Explanation of Minor Amendments to Plans

The West Midlands Rail Freight Interchange Order 201X

21 May 2019

THE WEST MIDLANDS RAIL FREIGHT INTERCHANGE ORDER 201X
DOCUMENT 12.1 – EXPLANATION OF MINOR AMENDMENTS TO PLANS

B2 & B3 - Proposed Road Bridge, Over Existing West Coast Mainline and SI Group Access Road (Elevation E2)
(Scale 1:100)

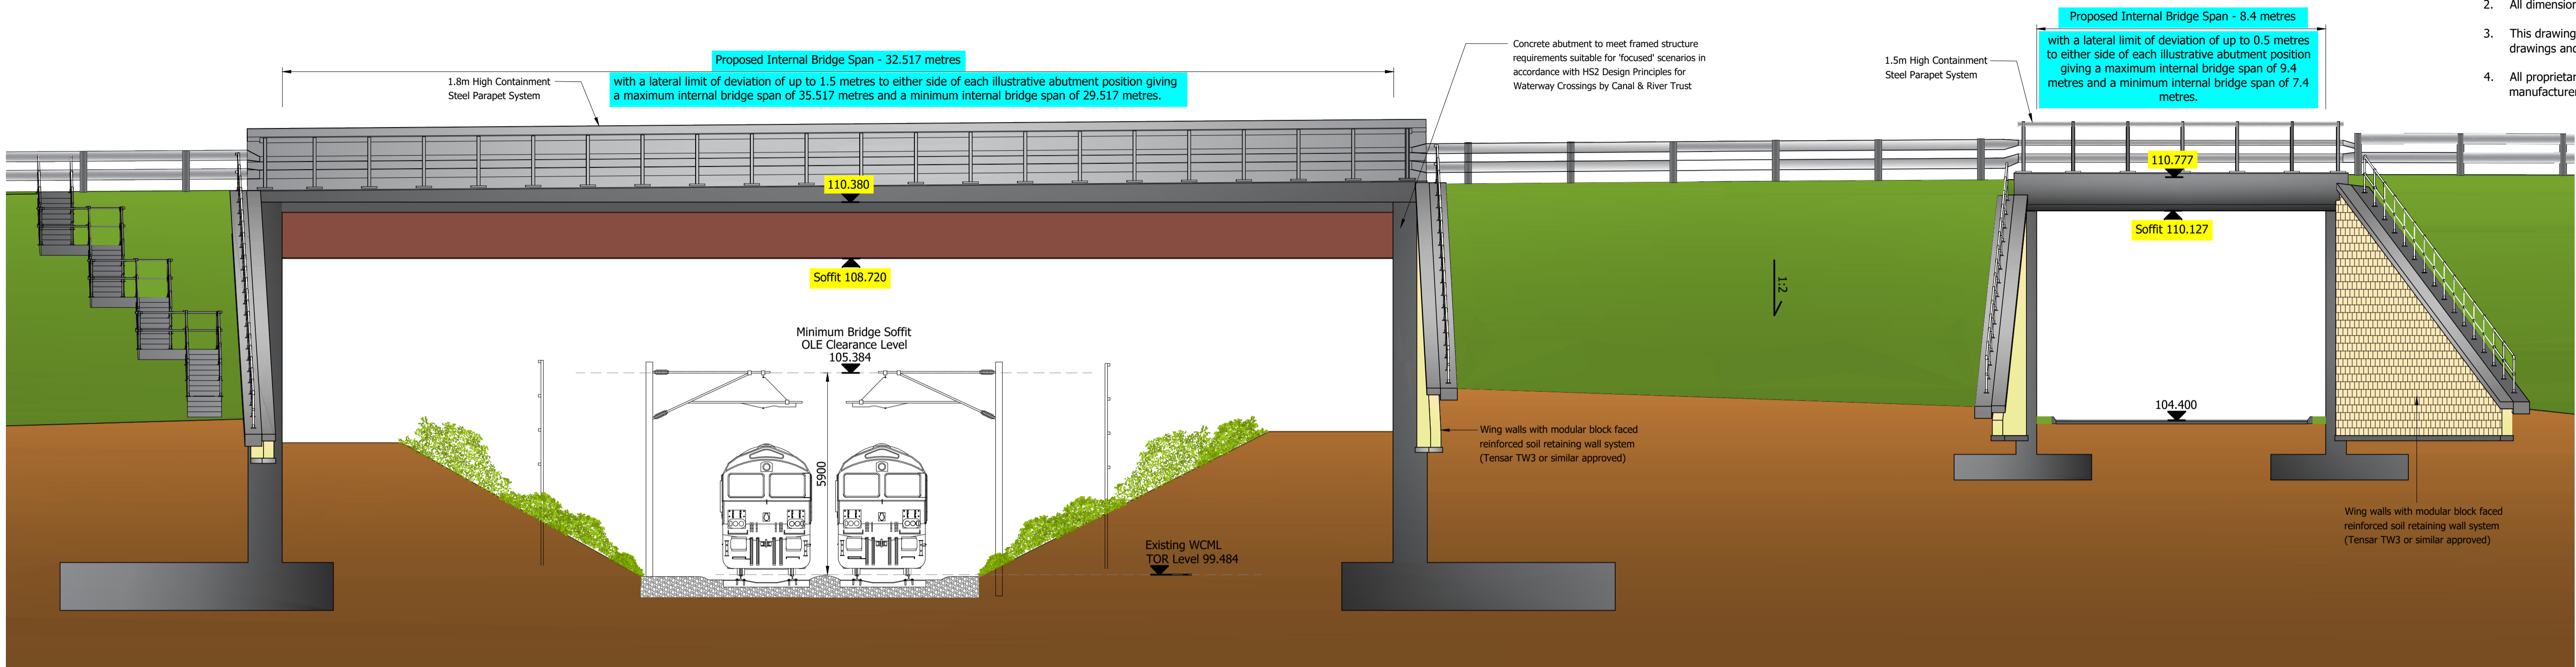
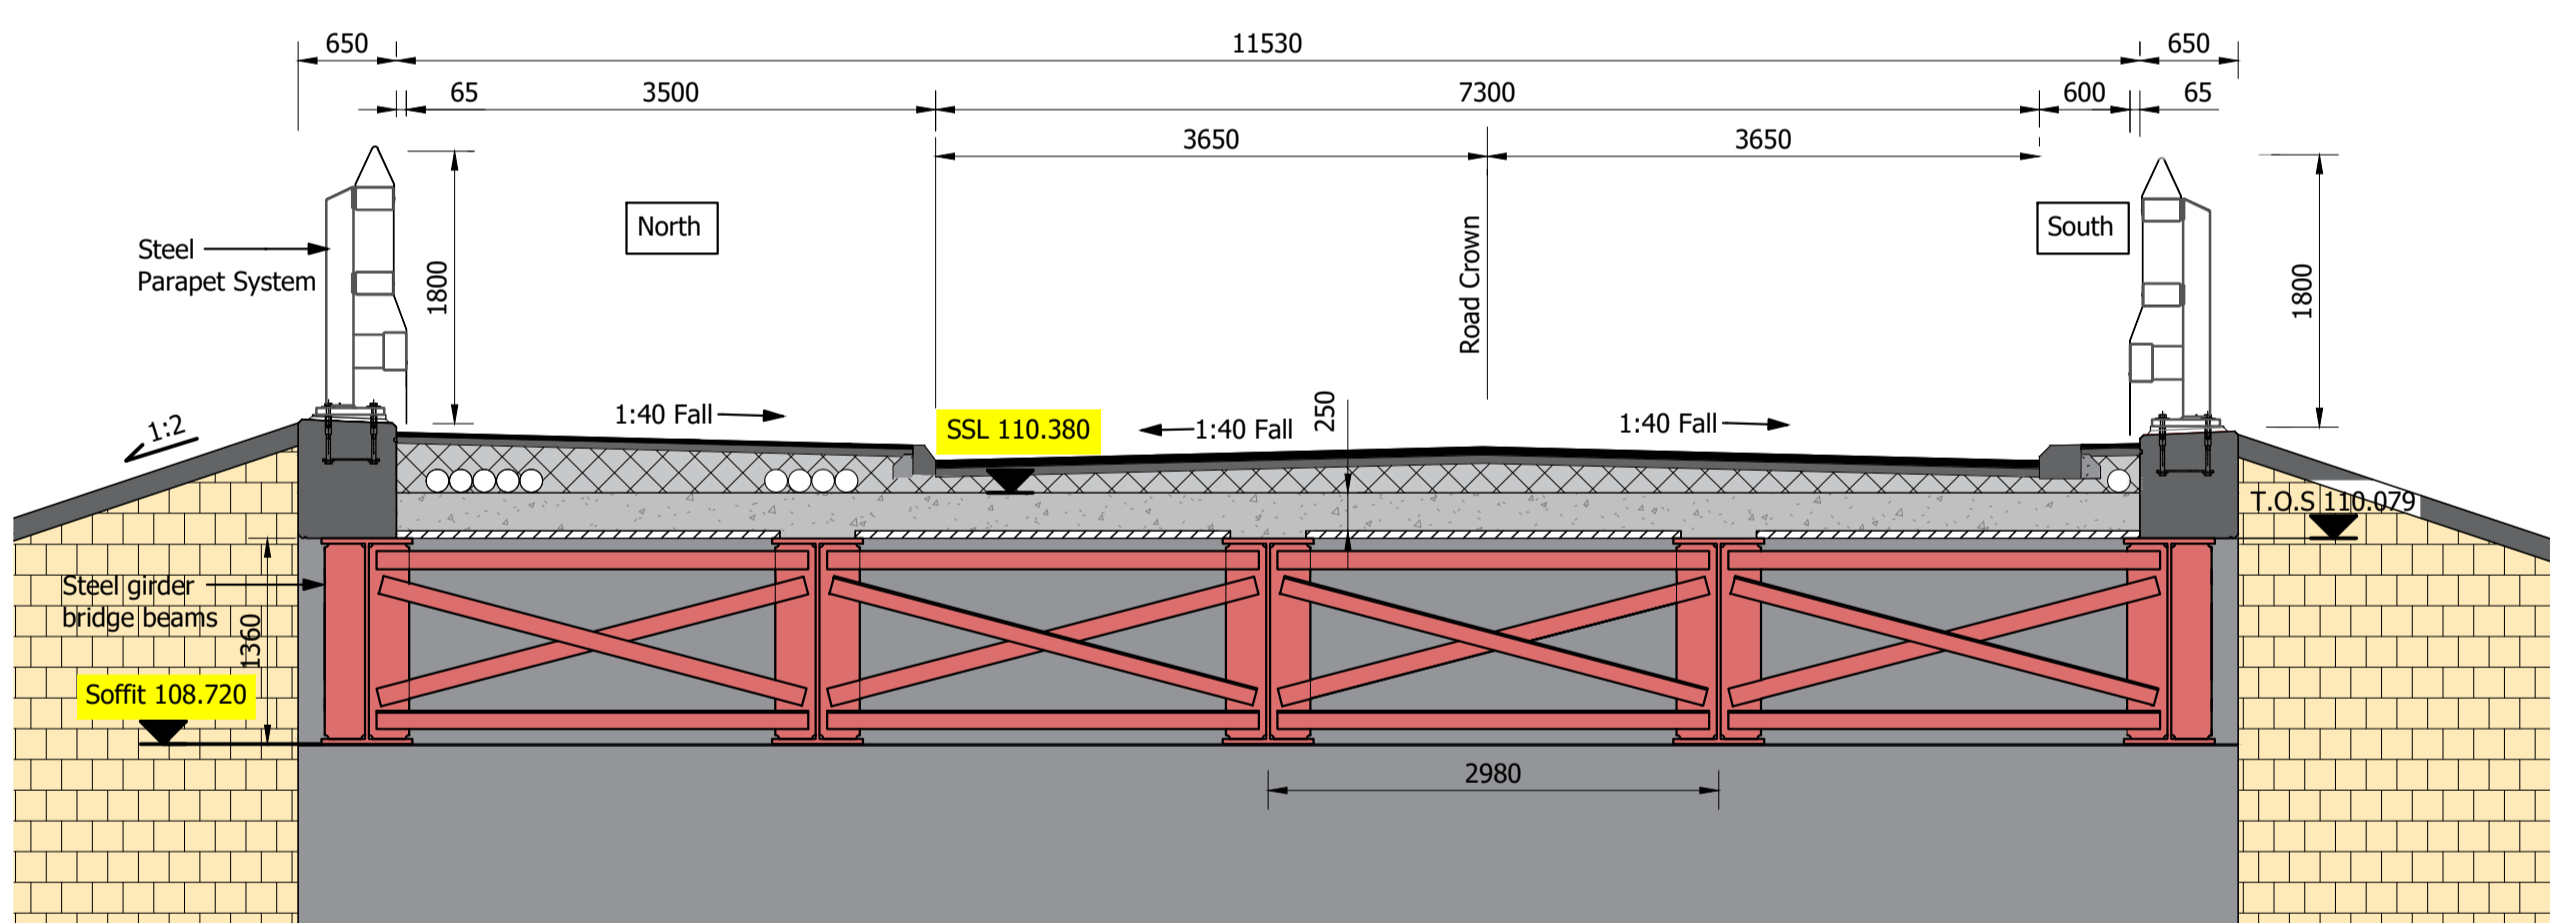
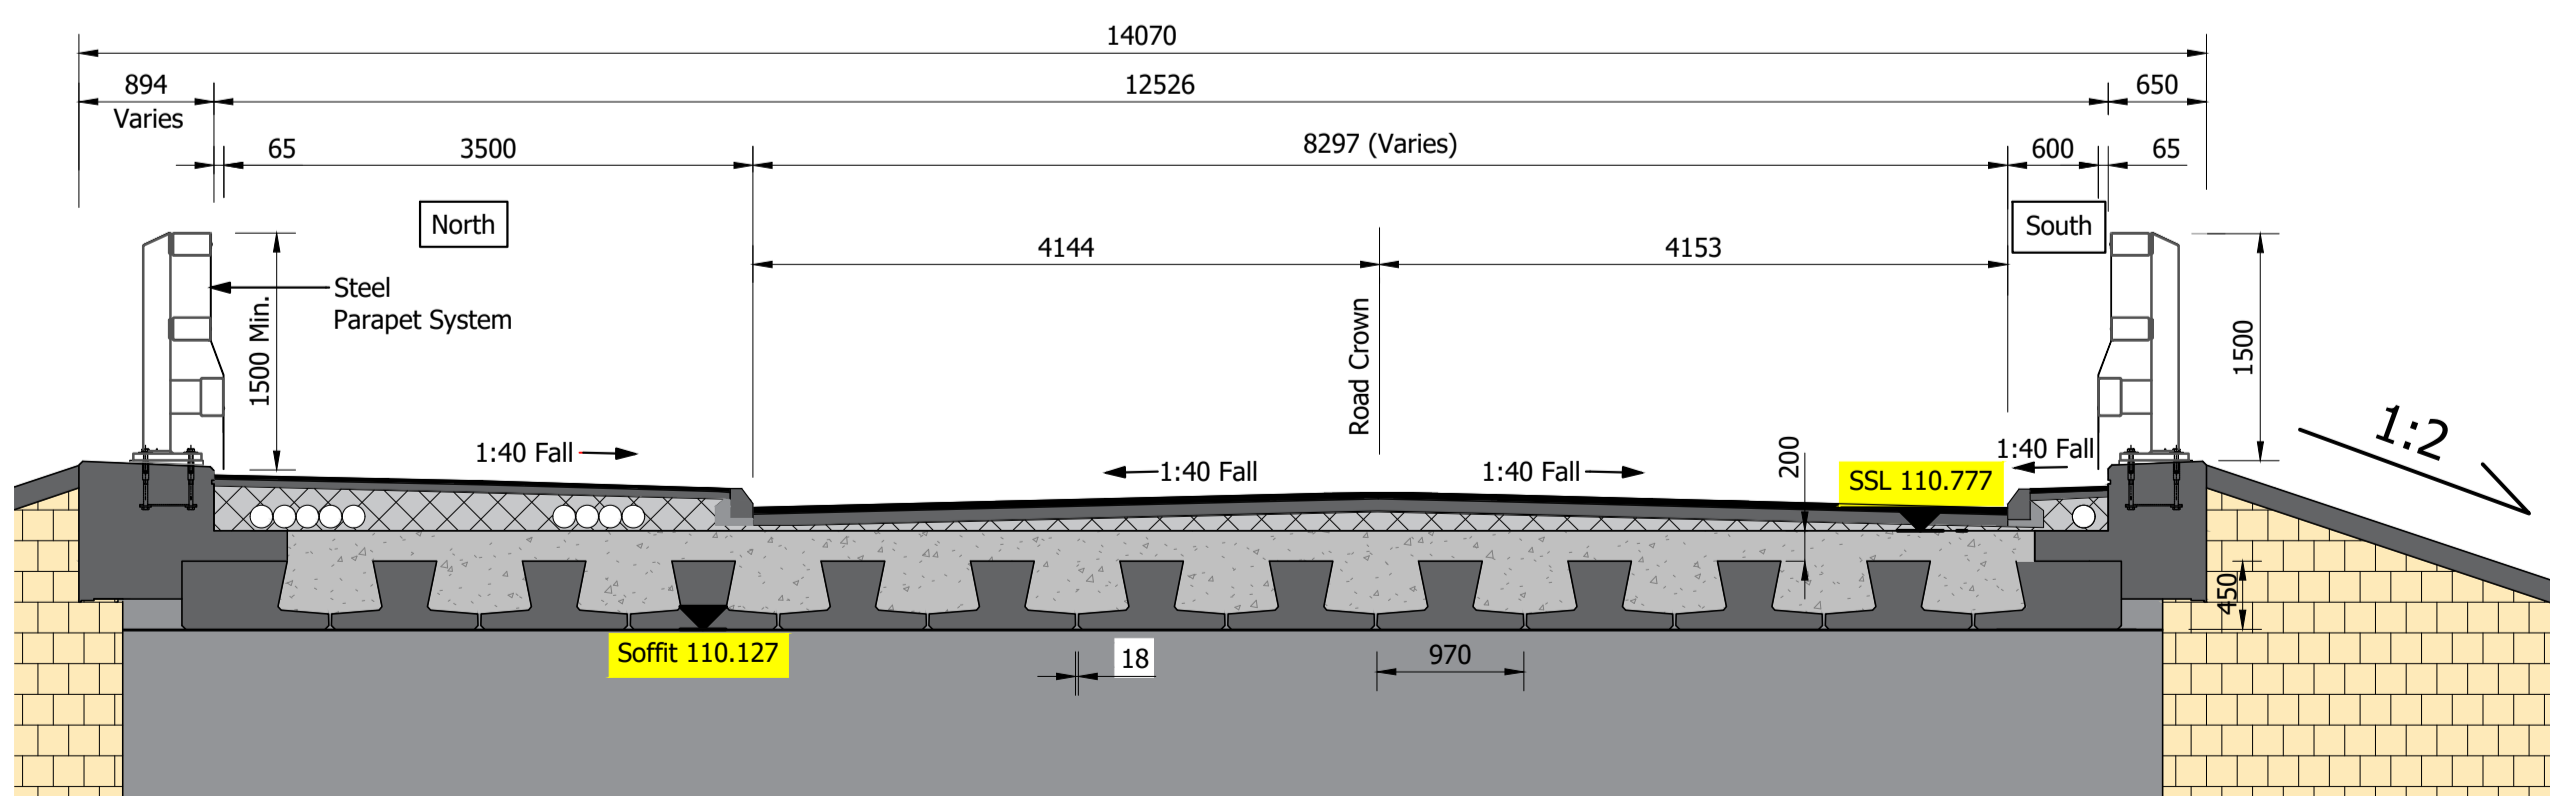
Doc No.	Doc Name	New Plan Rev Number	Changes and Reasons for Changes
Bridge Plans			
2.18A	Proposed Road Bridges Plan and Long Section	P8	To allow better cross reference to levels for limits of deviation in article 4 of the dDCO.
2.18B	Proposed Road Bridge B1 Section and Elevation	P11	As above.
2.18C	Proposed Road Bridge B2 and B3 Section and Elevation	P11	As above.
2.18D	Proposed Road Bridge B4 Section and Elevation	P14	As above.
